February 19, 2015

RE: Lazy Dog Restaurant, Addison Texas – Civil Engineering Revisions – Delta 4

The following letter summarizes the civil related edits made to the Utility Plan based upon contractor input regarding existing sanitary sewer facilities present at the site in regard to the Lazy Dog Restaurant, Addison, Texas project.

C5.0

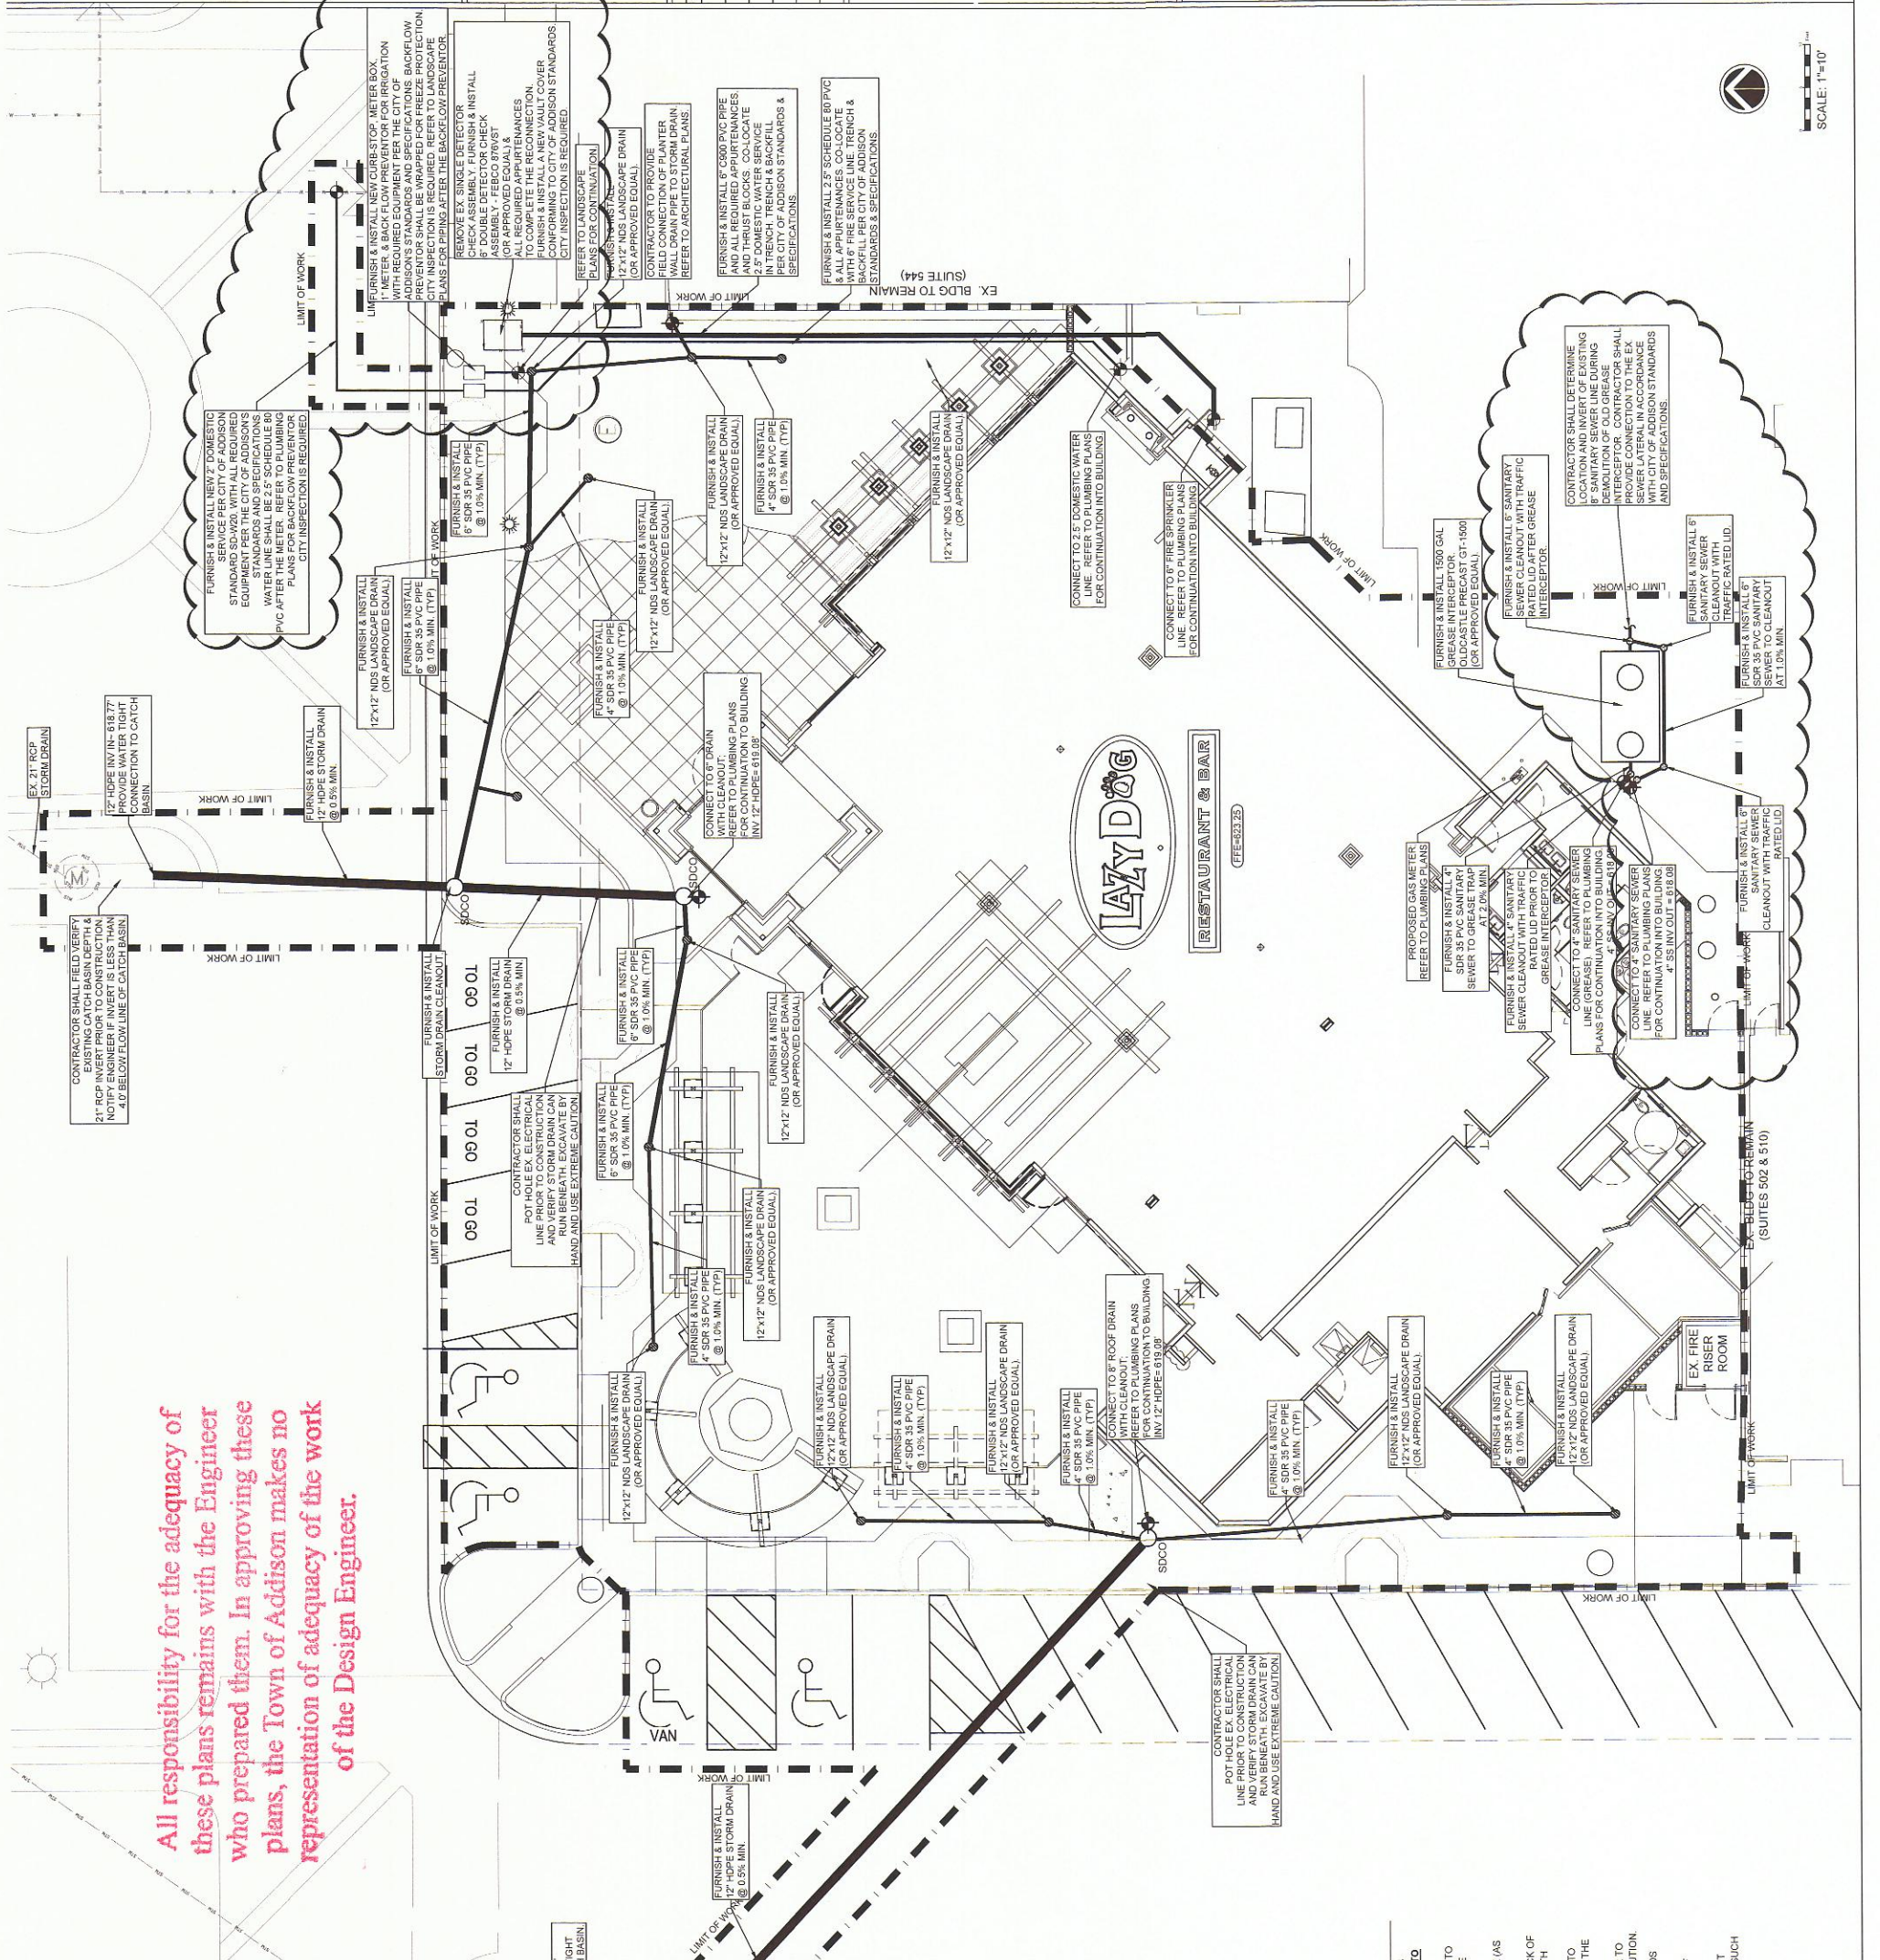
We have created Sheet C5.0A Utility Plan & Sheet C5.4 Utility Details to show the new 6" sanitary sewer lateral connection to the existing 8" sanitary sewer main in the drive aisle south of the project site. Based upon comments from the City, we were able to obtain a more recent as-built of the existing 8" PVC sewer line, entitled "5100 Belt Line Rd #500 (Plan Review A-2-Occ\_II-B Lazy Dog) 11-10-14.pdf."

1. Inverts provided into and out of the new Lazy Dog grease interceptor. Please note the manholes on the grease interceptor shall be fitted with risers, per manufacturer recommendations, to bring the manhole access to match finished grade.

2. Added approximately 197 linear feet of 6" SDR 35 sanitary sewer line at approximately 2.25% slope to connect to the existing 8" sanitary sewer line.

3. The new 6" line is located approximately 7.5' off the face of the westerly building. This may be adjusted 1-2 feet west/east in the field as needed based upon existing conditions encountered. Contractor to as-built exact location. Deviations greater than the 1-2 feet shall be approved by the owner.

4. Added 3 new sanitary sewer cleanouts with traffic rated lids. Sanitary sewer cleanouts shall be set to match finished grade.
5. Added 4 details provided by the City of Addison, for utility trenching and repair, to new sheet C5.4.
